PL-Consultation- Conservation Officer response

LU/234/25/PL

5 Selborne Place Selborne Road Littlehampton BN17 5NH

Single storey rear extension and alterations. This application affects the character and appearance of the Littlehampton Sea Front Conservation Area and is in CIL Zone 4 (Zero Rated) as other development.

PROPOSED SIDE ELEVATION. 1:100

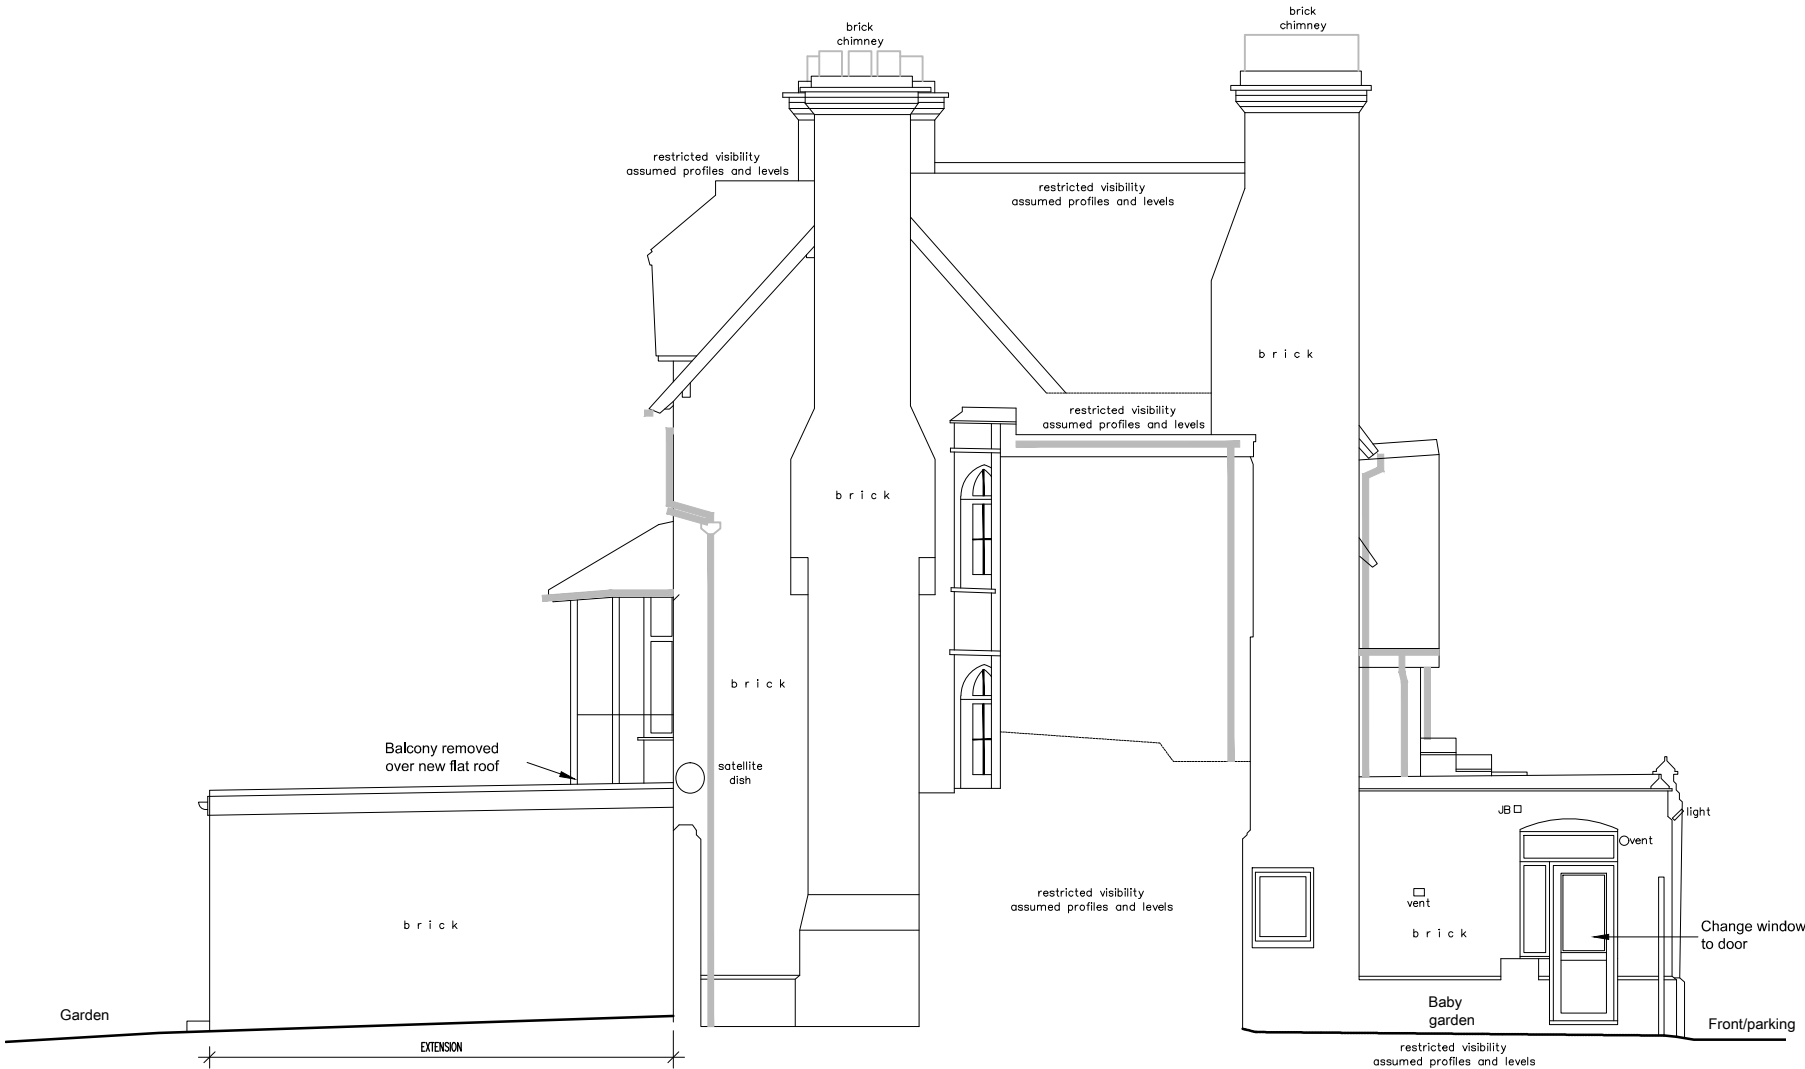
The proposed extension is essentially a flat-roofed, simple, box-like addition, and it is not clear how its design has been informed by the distinctive appearance and architectural character of the host building. The new extension would interfere with the legibility of the original rear elevation of the building. The extension would require the removal of the rear ground floor wall which includes what appears to be a hood-moulded Gothic Revival double-arched window and door, along with the lower portion of an attractive two-storey angled bay window. These features make a clear contribution to the architectural interest of the building, and their loss would cause harm.

It is therefore surprising to see the assertion in the heritage statement that “clearly there is no meaningful harm whatsoever to historic structure, fabric”. This conclusion is difficult to understand, as the proposal would result in the loss of a substantial part of the ground-floor rear elevation, which appears to retain its original form, detailing and historic materials.

sympathetic joinery and design. This does not appear to have been considered. Although I am aware that there are nearby extensions of a similar nature within the group of houses, especially the one at the rear of numbers 3 & 4, this does not generally relate well to the host building and therefore cannot be taken as setting a precedent for the current proposal. This is important in the sensitive heritage context. The extension would also be visible from the road to the rear which would not have a positive impact.
